KITTITAS COUNTY COMMUNITY DEVELOPMENT SERVICES

RE: BL-18-00011 Fyall

RE: Transmittal of Comments and Request for Additional Information

*Alternate Site Plan*

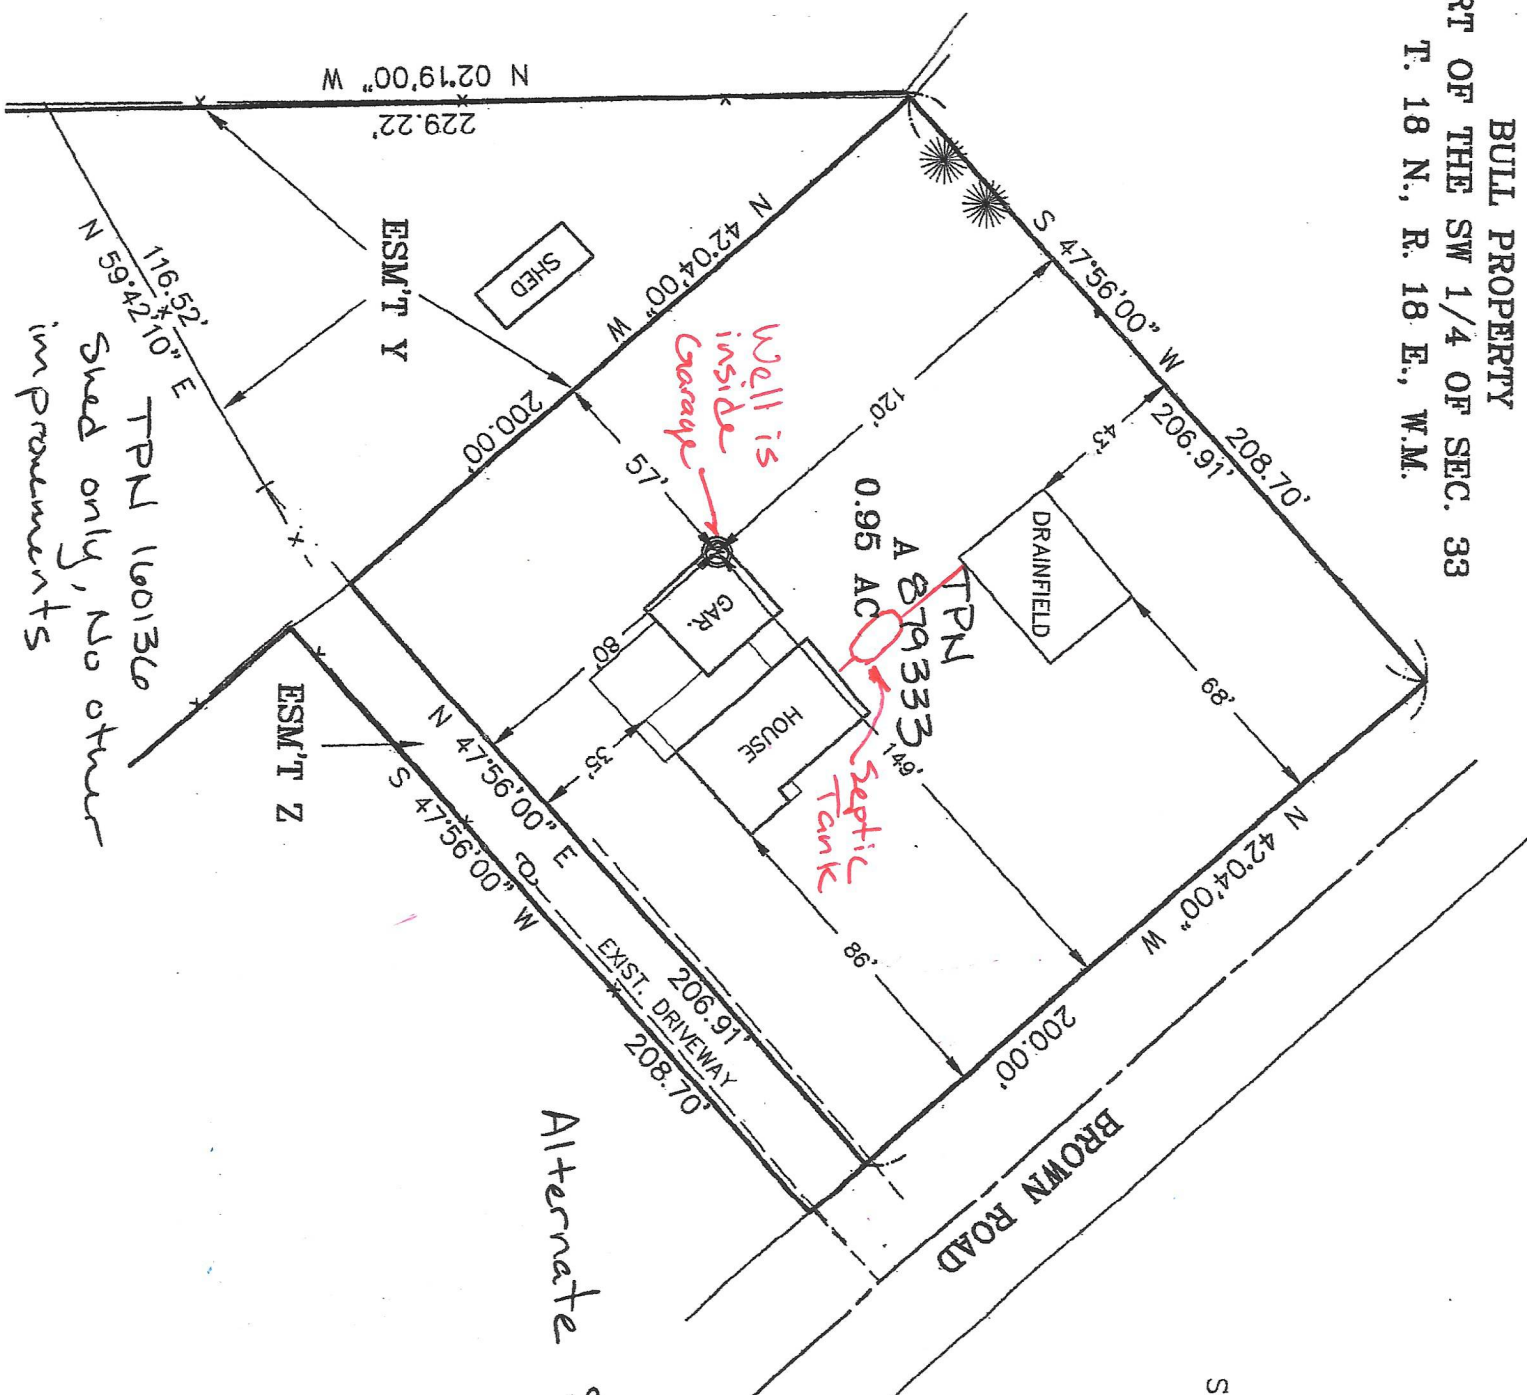
As requested in the letter from Kelly Bacon, clarification is required as to which of the two site plans submitted will be reviewed. In making this decision, bear in mind that the site plan marked "Alternate" will meet Kittitas County Code (KCC) 16.10.010(3), which reads "No nonconforming lot shall be adjusted in a manner that increases the nonconformity". The "preferred" site plan does not meet KCC 16.10.010(3) because it will make a lot more nonconforming and cannot be approved by CDS.

In addition, upon further review of the provided "Alternate" site plan, it appears that the setback from the shed on parcel # 160136 is not clearly labeled. Please provide a revised site plan demonstrating that the 25 foot front yard setback is met as required by KCC 17.28A.040.

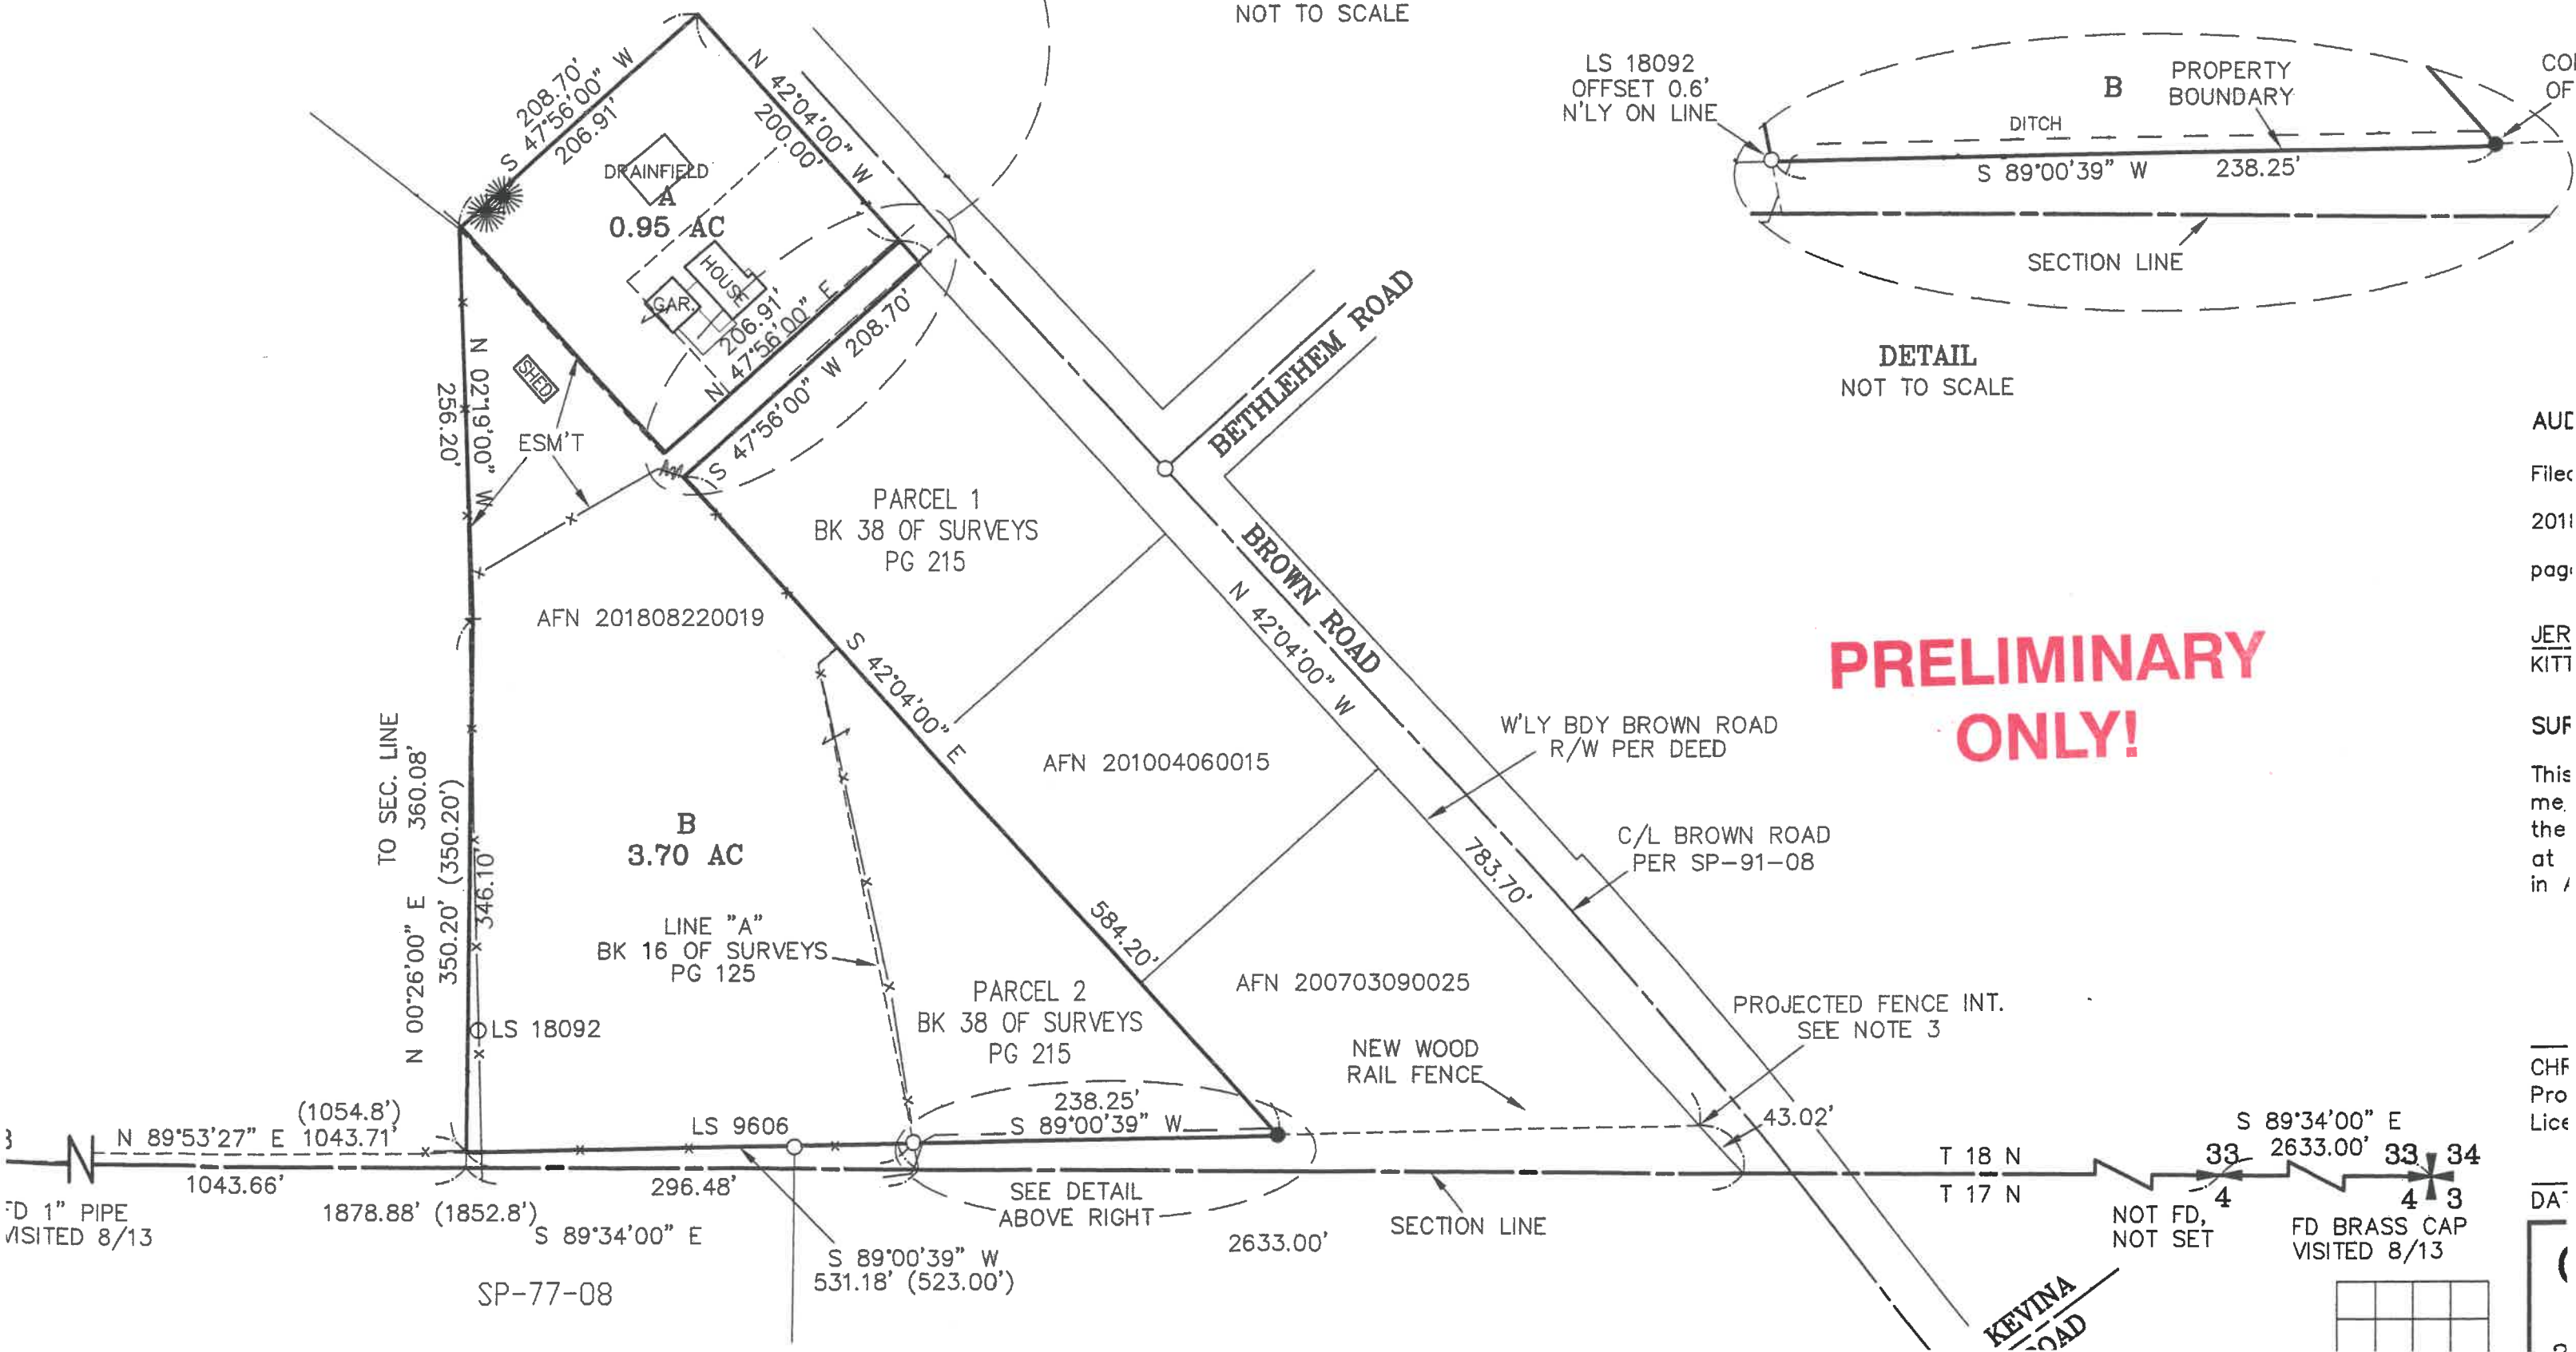
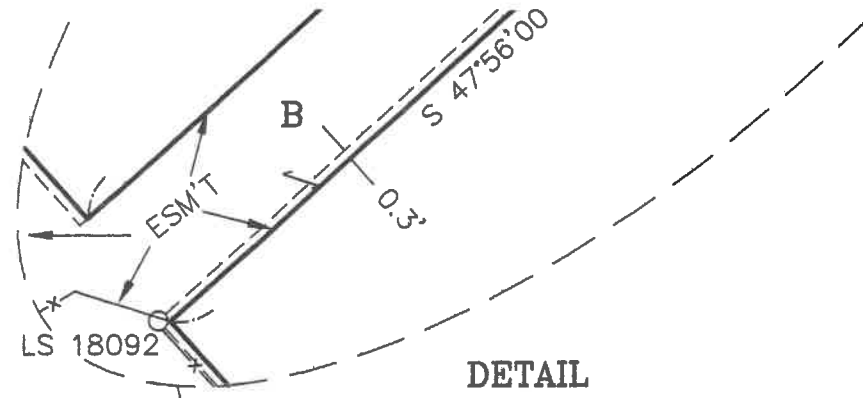
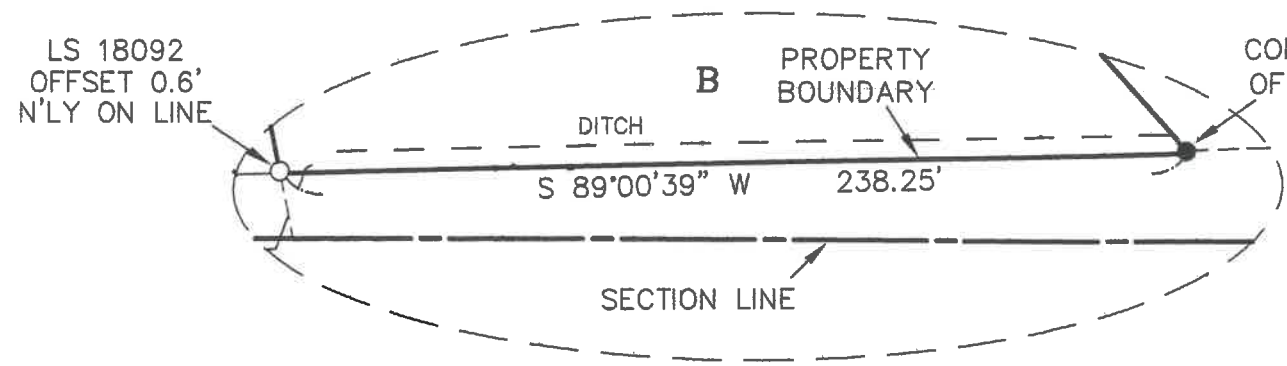
There are two different layouts included in the packet. I need clarification as to which one they are applying for, in order to complete my comments.
